CITY OF ALBUQUERQUE

**RE: El Rancho Grande Unit 18
99999 Gibson SW
Grading and Drainage Plans
Engineer's Stamp Date: 08/20/25
Hydrology File: N08D007
Case # HYDR-2025-00300**

Based upon the information provided in your submittal received 08/19/2025, the Grading & Drainage Plans **are not approved** for Grading Permit or Building Permit. The following comments need to be addressed for the approval of the above referenced project.

CITY OF ALBUQUERQUE DEPARTMENT OF MUNICIPAL DEVELOPMENT ENGINEERING DIVISION	
	EL RANCHO GRANDE UNIT 18 OVERALL GRADING PLAN	
	DESIGN REVIEW COMMITTEE	CITY ENGINEER APPROVAL
CONCEPTUAL NOT FOR CONSTRUCTION		ZONE MAP NO. -----
		CITY PROJECT NO. -----
		SHEET NO. 4

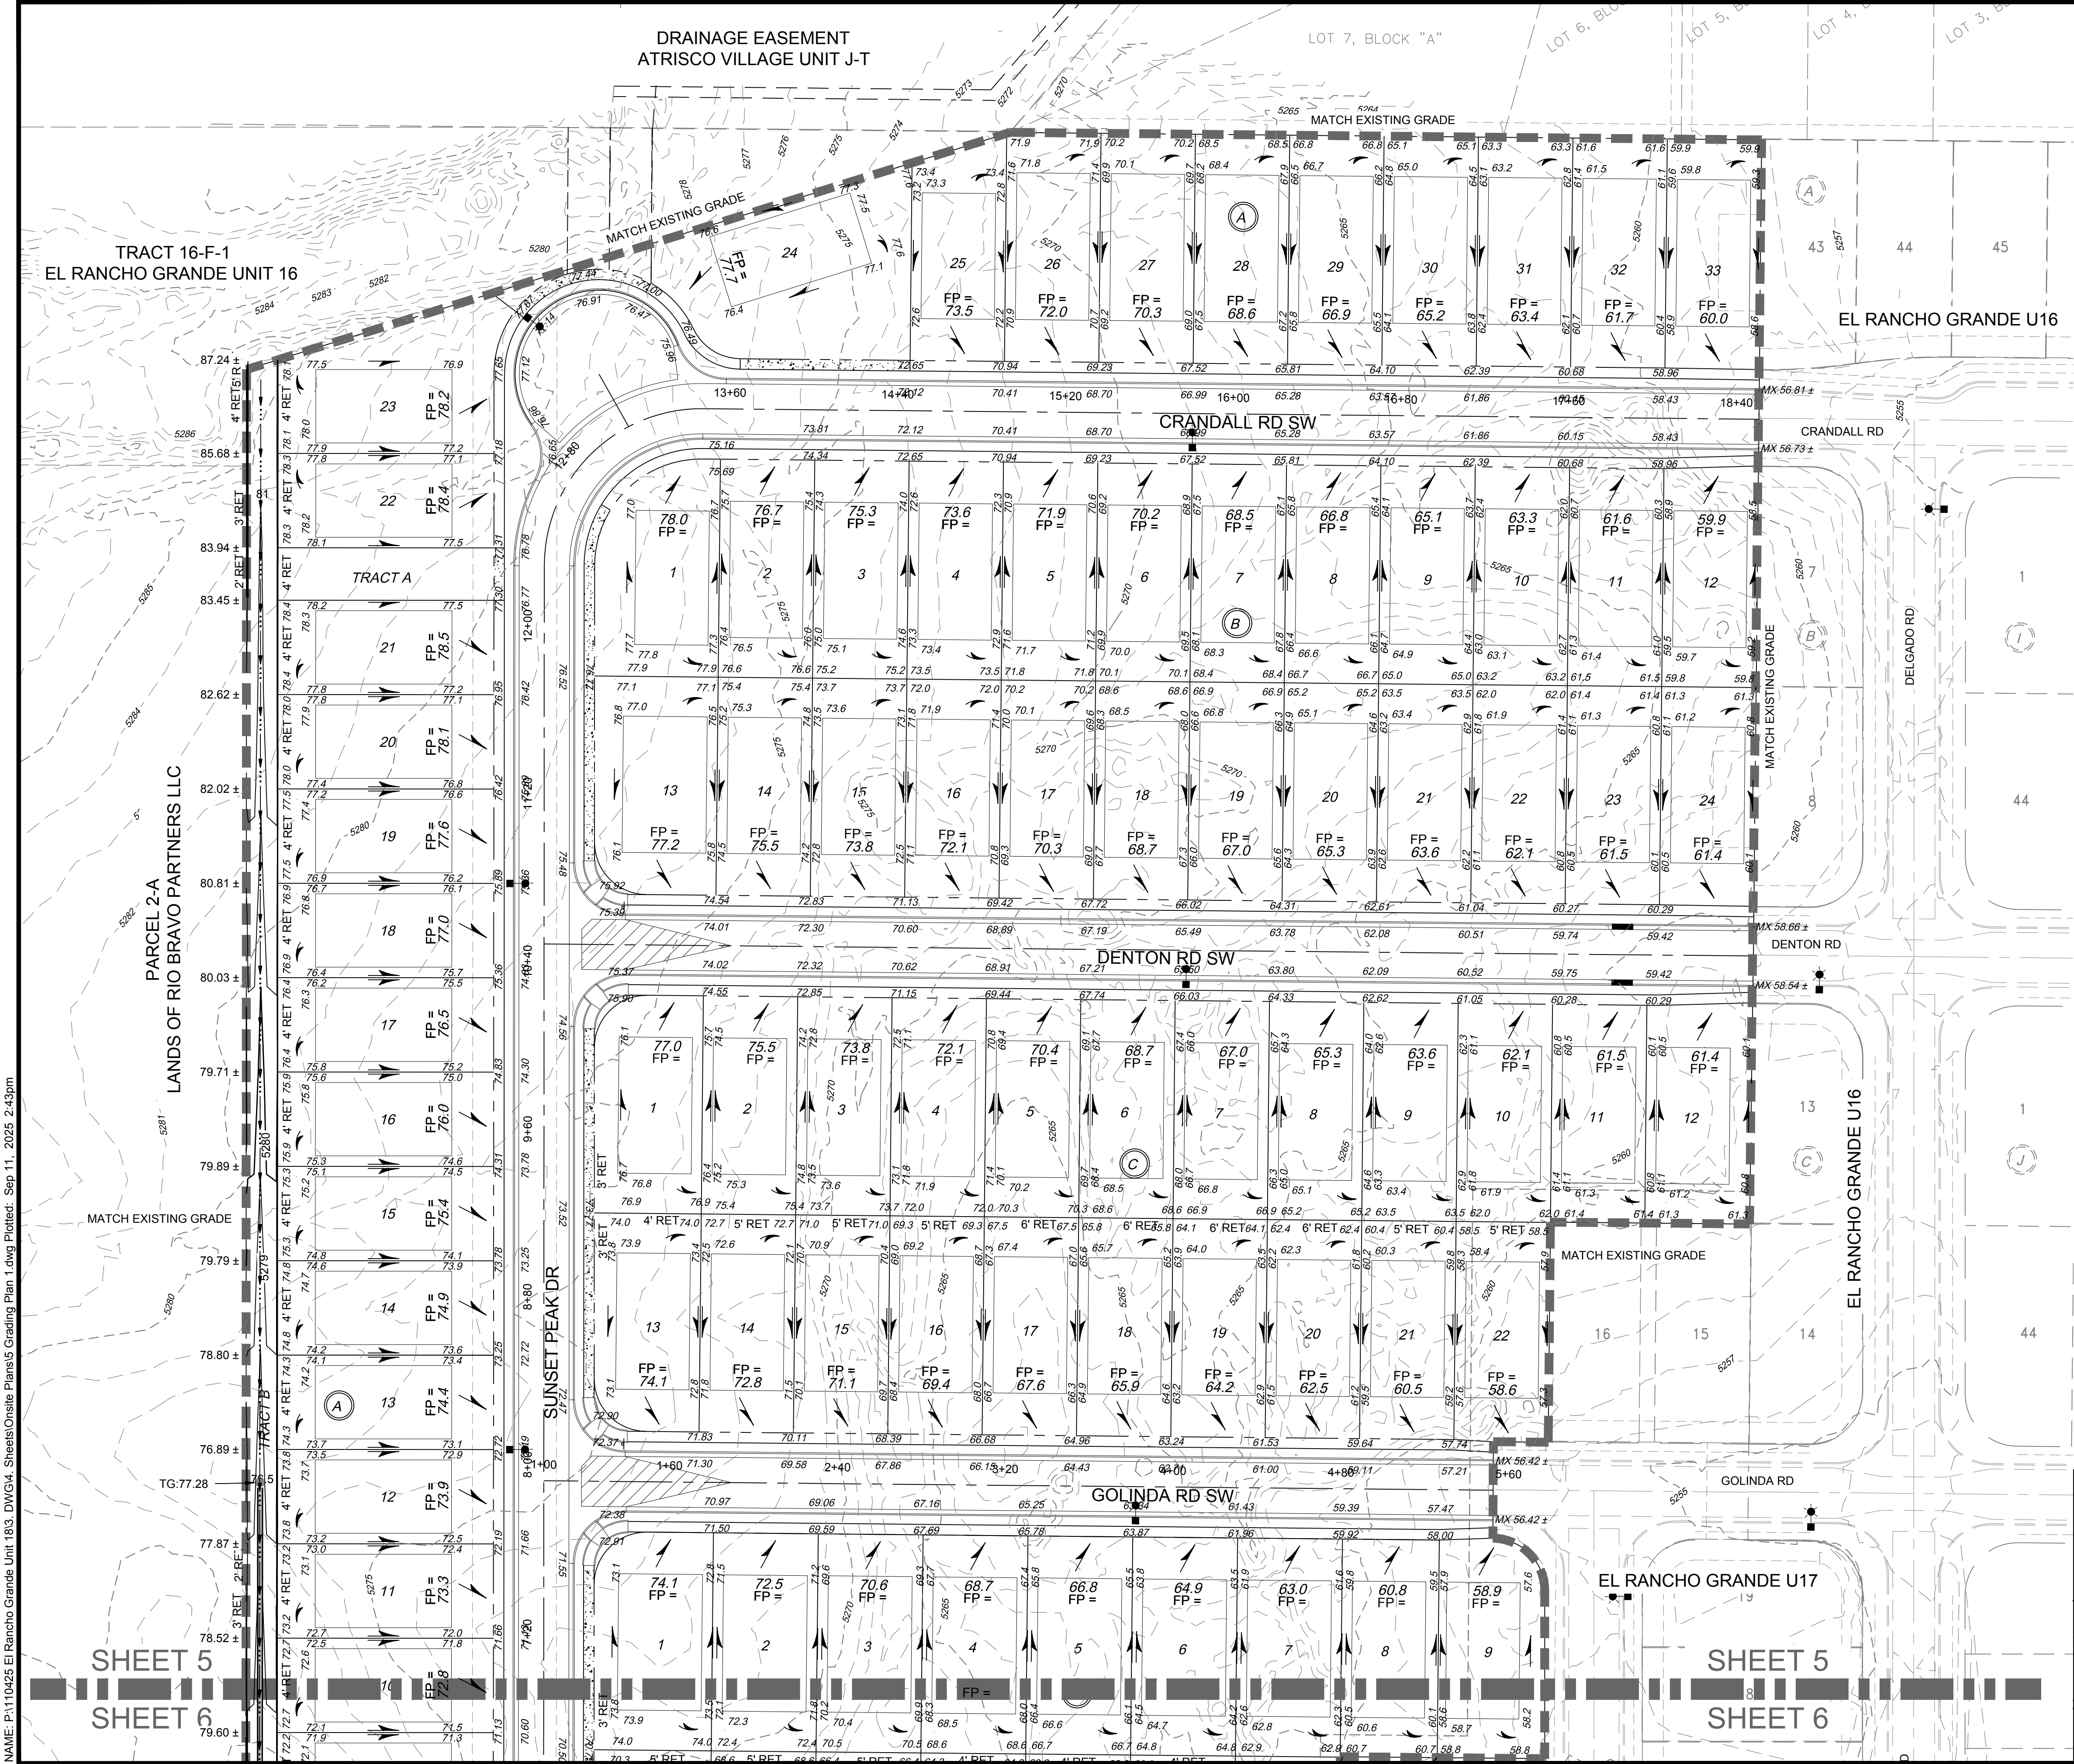
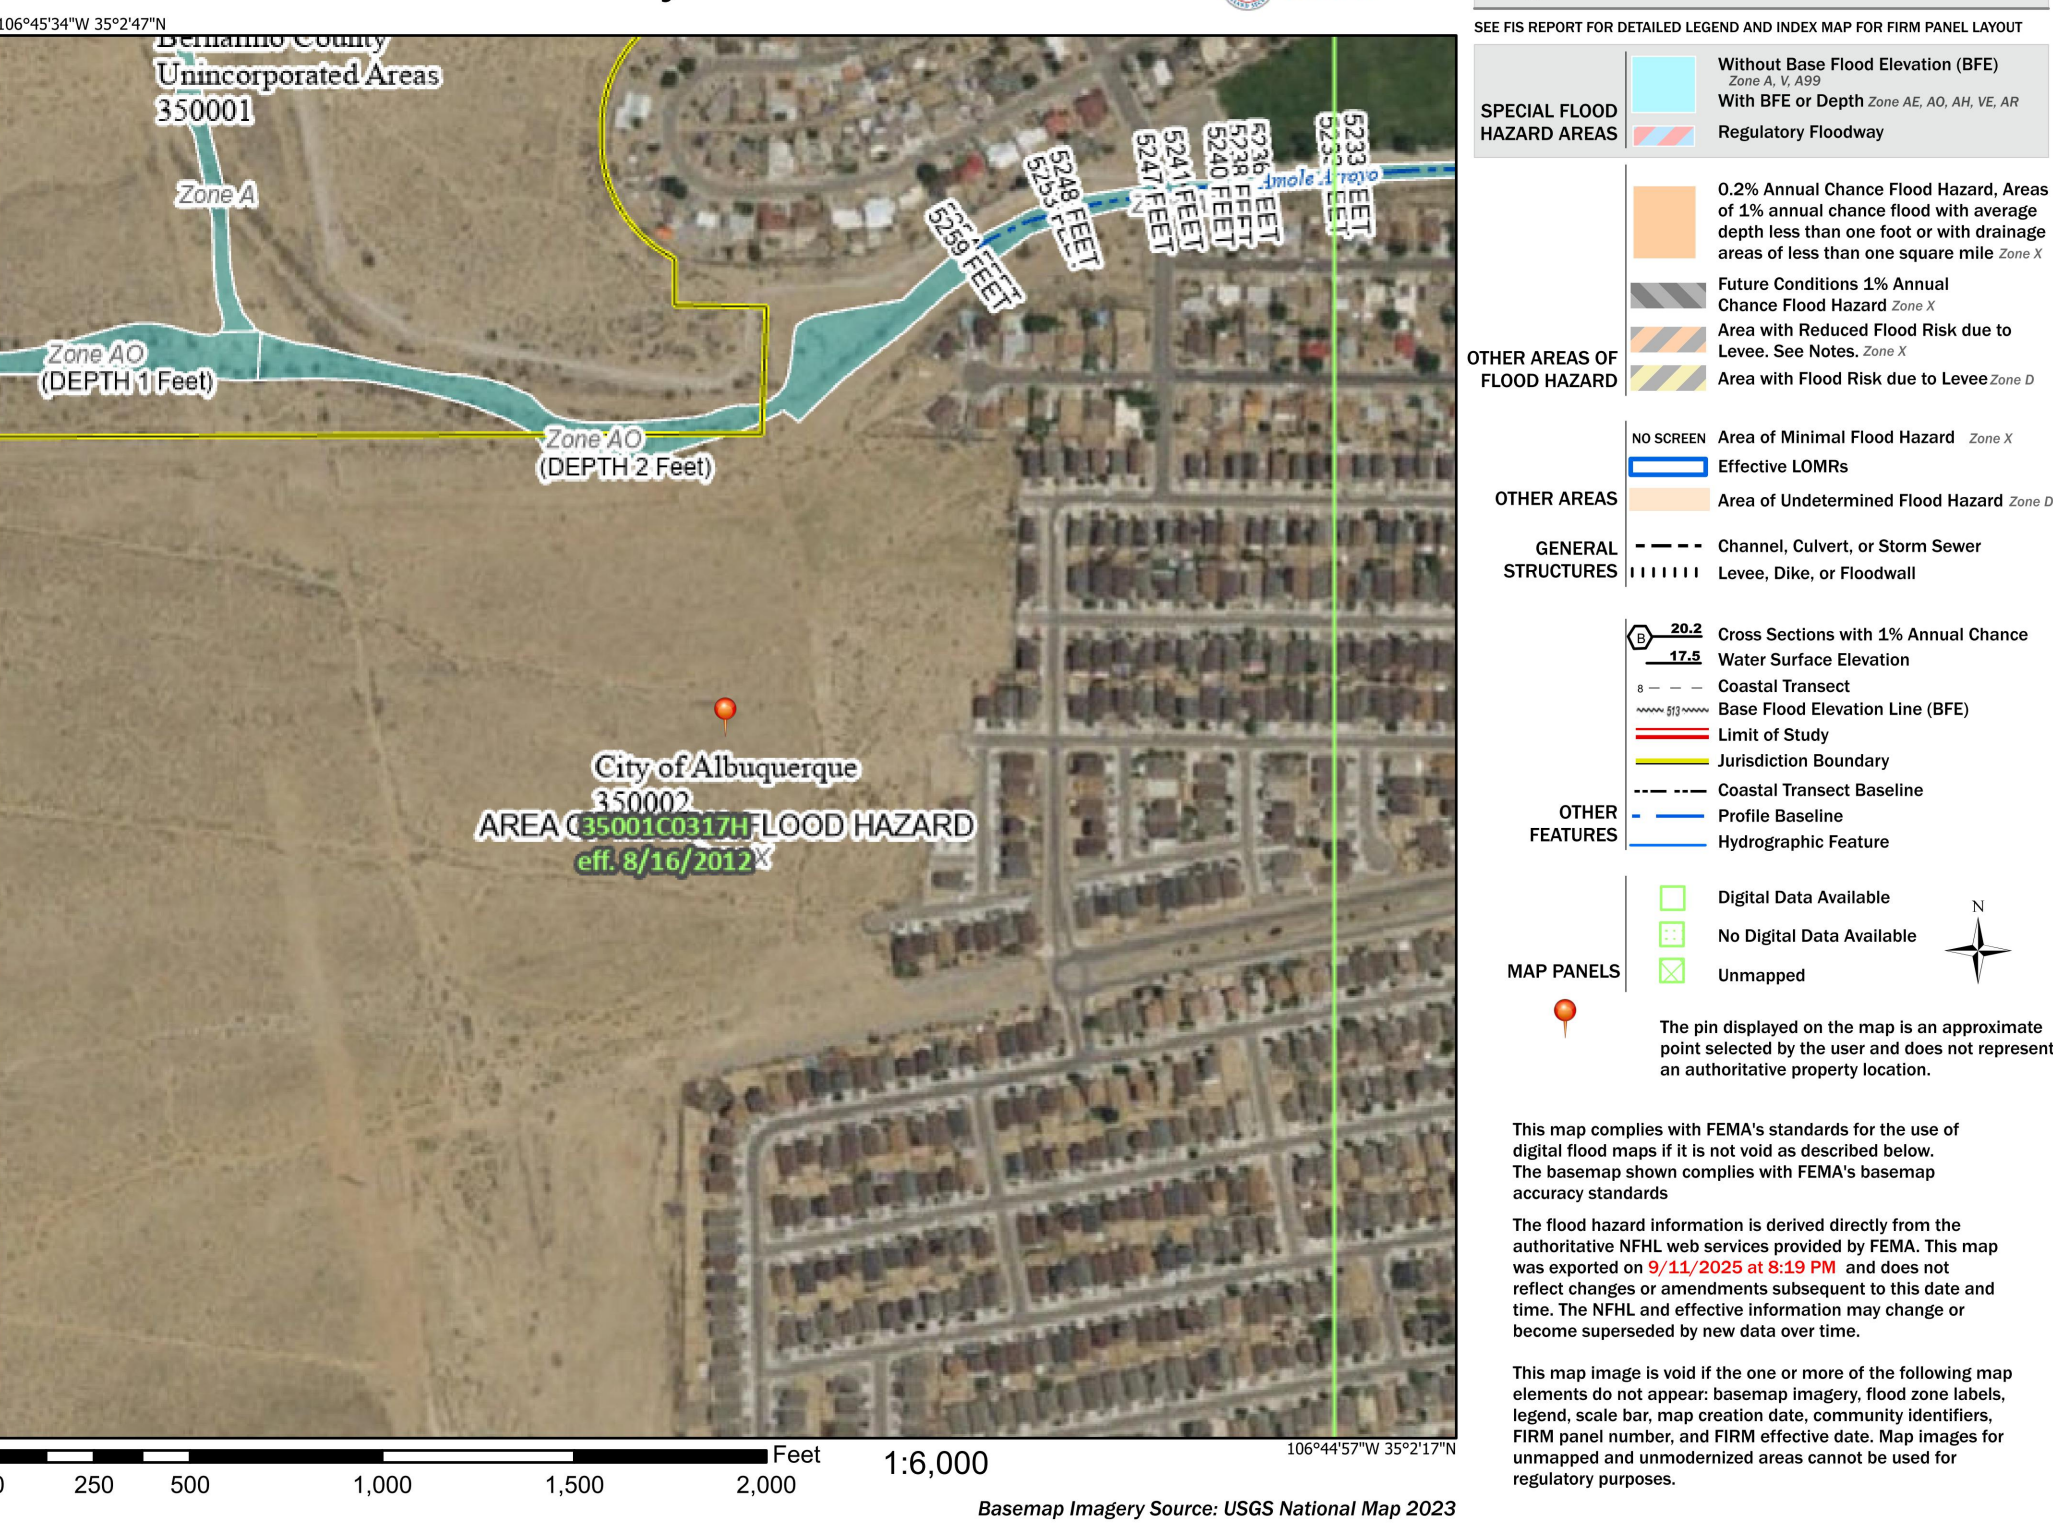
2. Please provide the FIRM Map and flood plain note with effective date.
3. Please provide the legal description of the property.
4. The total required SWQV calculation must be included on the Grading and Drainage Plan along with the calculation of the portion of the SWQV for which payment-in-lieu is requested.

5. Please add a note which states, "The Owner has elected to pay the Payment in Lieu for the required Stormwater Quality Volume."
6. Payment in Lieu (Amount = $14883\text{CF} \times \$6/\text{CF} = \$89,298$, per sheet 9 of the Drainage Report) of onsite management of the SWQV must be made. Please submit the Waiver Application to Hydrology for review and approval.

EL RANCHO GRANDE UNIT 18
GRADING PLAN 1

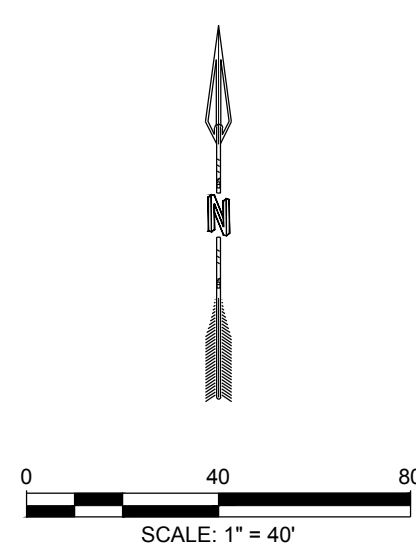
1. If only seeking Site Plan for Building Permit approval at this time, label the grading plan "Conceptual, Not For Construction" or similar and address the SPBP comments. If seeking SPBP and Building Permit simultaneously, forgo the conceptual markings and address all SPBP and Building Permit comments. Note that the G&D Plan can not be approved if there is a Payment-In-Lieu pending.
